Application No: AW/108/22/HH
Site Address: 22 Gossamer Lane Aldwick PO21 3BY
Description of works: Installation of concrete surfaced driveway.

Thank you for your internet representation made on 10th May 2022 which has been recorded as an objection with the comments as follows:

Proposed Concrete Drive and Turning

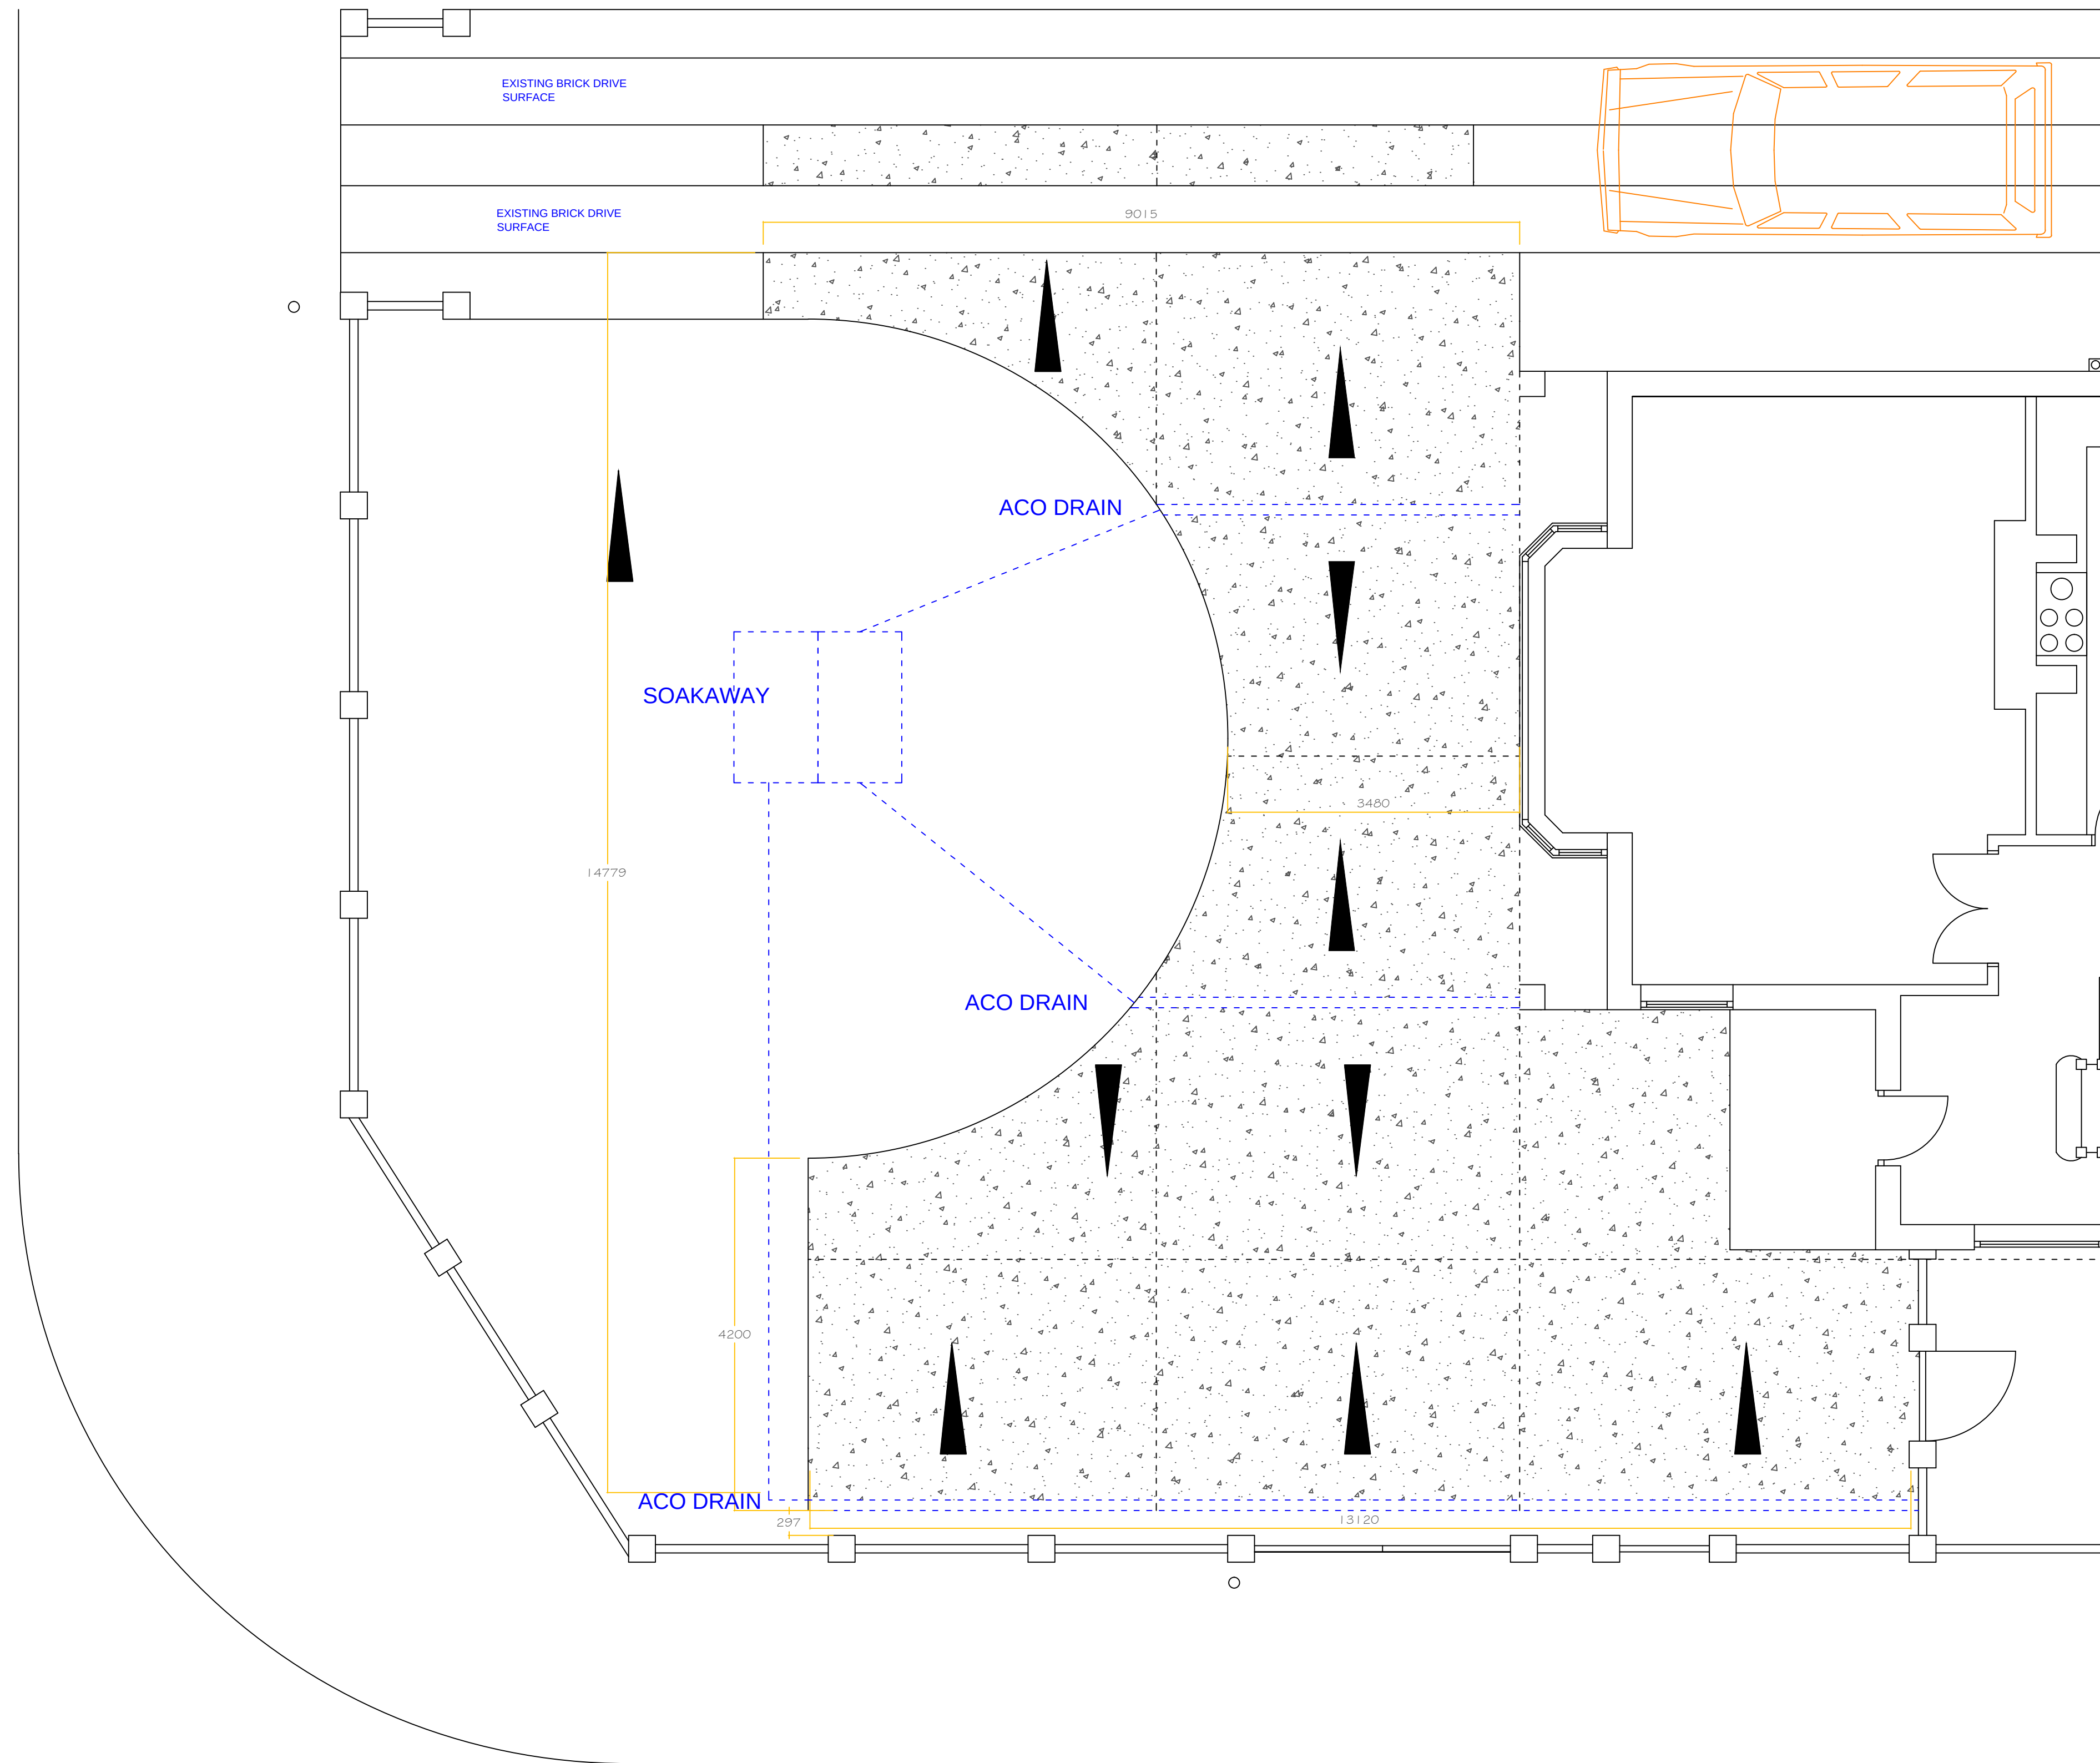
Members objected to the application on the grounds of a lack of permeability in relation to the surface. Members also expressed the view that a surveyor should examine the site in order to ascertain that there is sufficient drainage in line with planning law. Members moreover believe that a loss of hedgerow will result from the application which does not contribute positively to the quality of the

environment

Members therefore considered that the proposed application is in direct conflict with

Policies QE SP1 and with Policy W DM3 of the Arun Local Plan 2011 2031 and with the Parish Design Statement (p 45)
